**Consultation Response from KC,
Lead Local Flood Authority**

2022/91477 Land off Lindley Moor Road, Lindley, Huddersfield, HD3 3SX

Hybrid Planning Application for the erection of an industrial unit for E(g)/B2 /B8 use with associated access, parking, groundworks and landscaping in conjunction with an outline application for mixed use development use class E(a), E(b), E(g), B2 and B8

Date Responded: 21st March 2023

Contributing Areas Plan

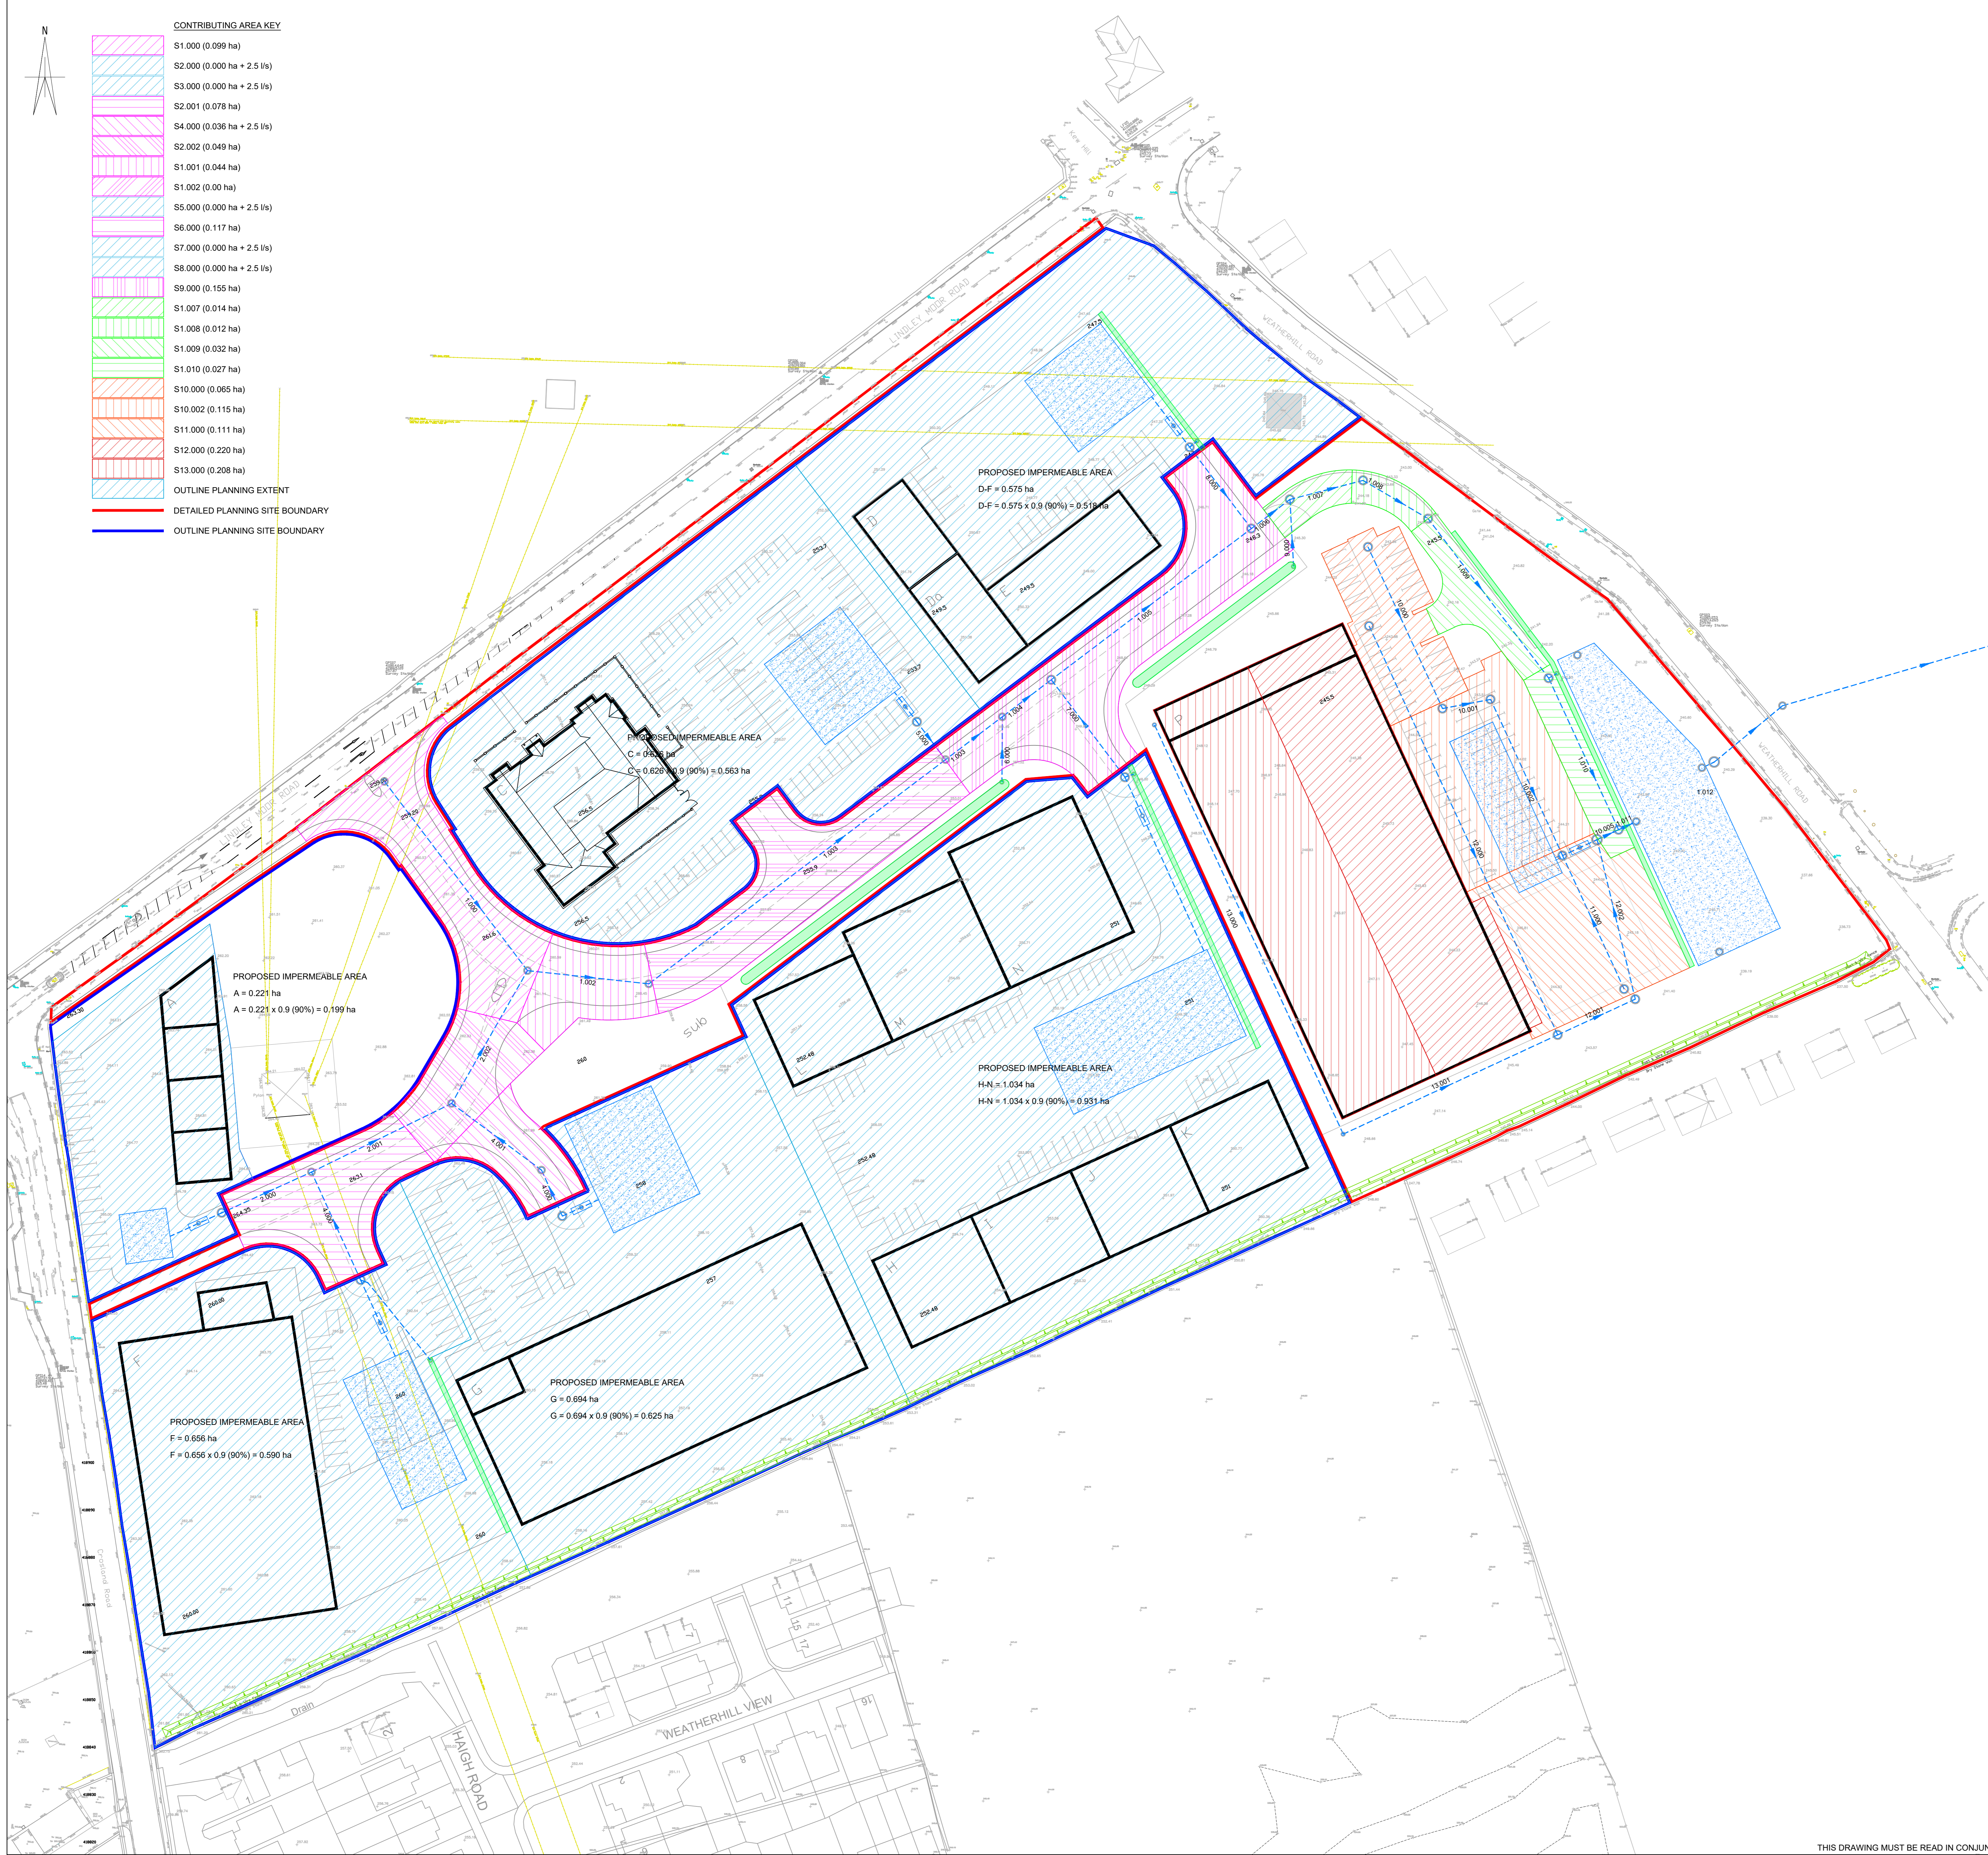
In a revised FRA, a coloured catchment drawing showing contributing areas to each phase/sewer leg is required and matched with the microdrainage output.
